March 9, 2001

Re: Building Code Stair Width Waiver Request (55 B052)

This Office has reviewed your written request for waiver pursuant to Section 121.1 of the City of Portland Building Code (1999 BOCA as amended). The following are the facts:

**Bampton Kitchen
11 Houlton St
Detail 1: Stairs**

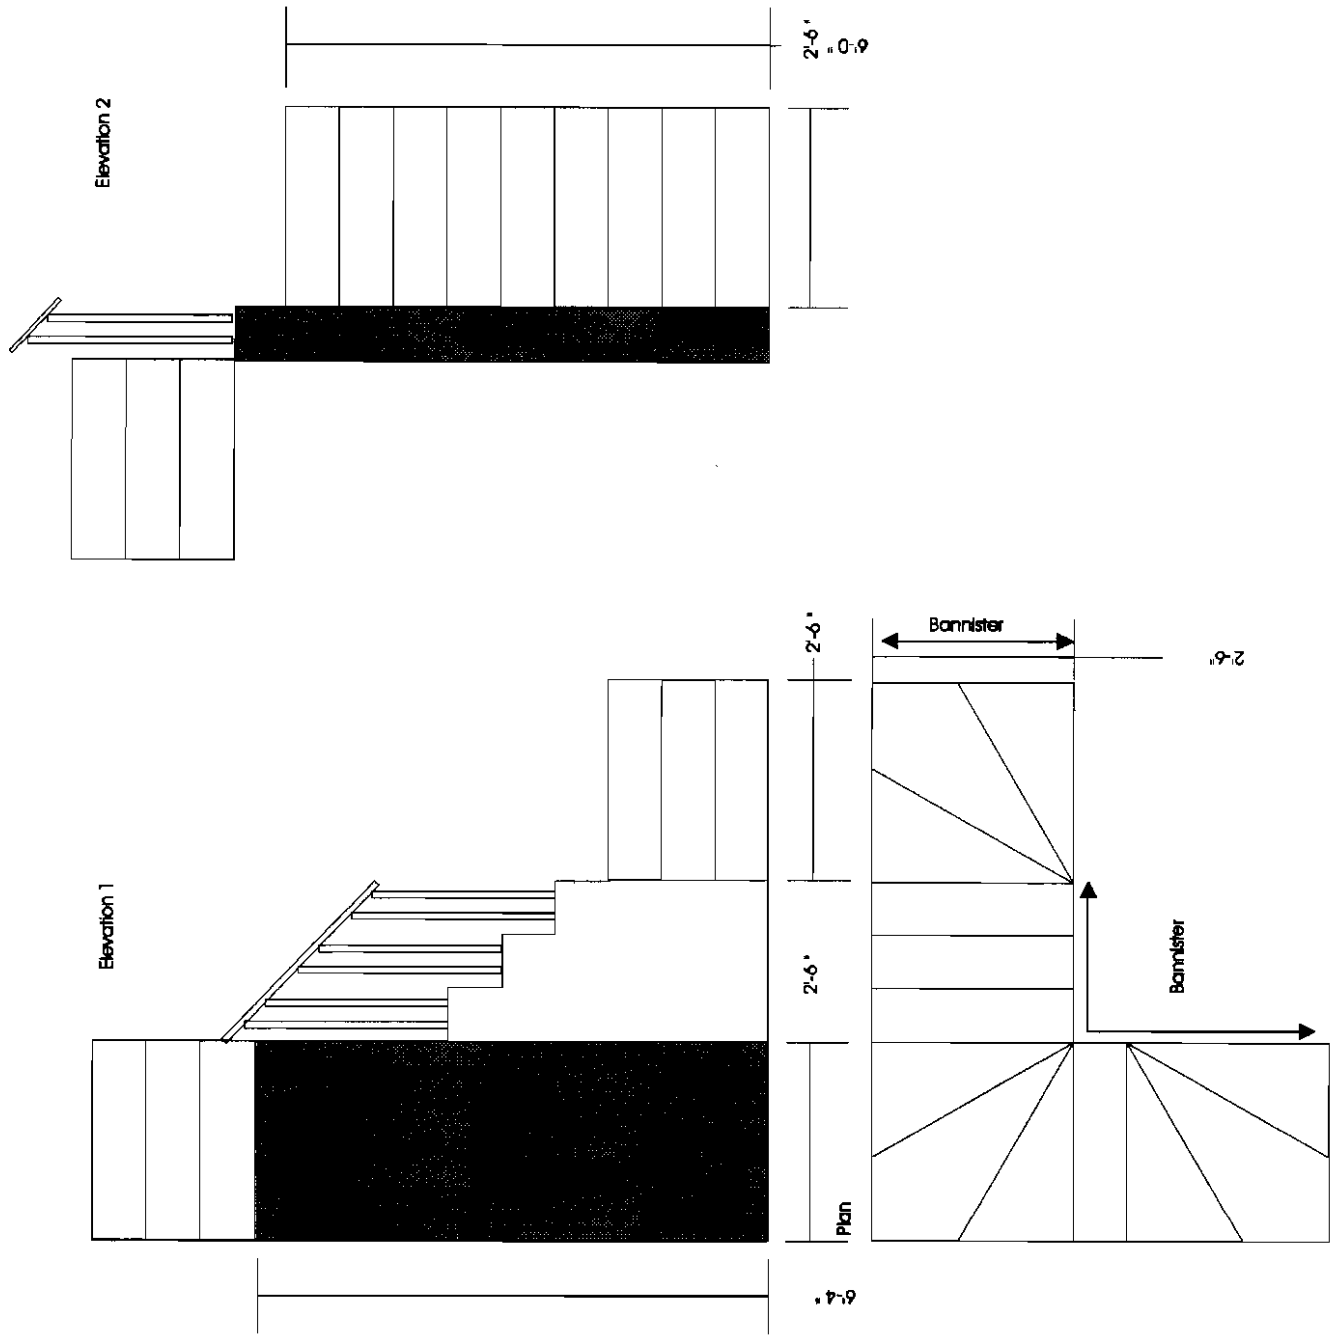
1. The use of the property is a single-family dwelling.
2. There are two stairways that communicate between the first and second floors.
3. The front existing stairway is 36 inches in width.
4. There is a structural beam in the kitchen that limits the ability of the builder to create a 36" stairway.
5. The proposed reconfigured stairway that discharges into the kitchen will be 32 inches in width.
6. The proposed reconfigured stairway that discharges into the kitchen will comply with all other provisions of the code including the winder provisions and headroom.

Based on these facts, this office finds that replacing the stairway that discharges into the kitchen with a code compliant width would create an undue hardship due to existing structural conditions. The proposal is not inconsistent with the purpose of the ordinance and is hereby granted subject to facts 1 through 6, which become conditions herein. Please feel free to contact this office if you need further assistance.
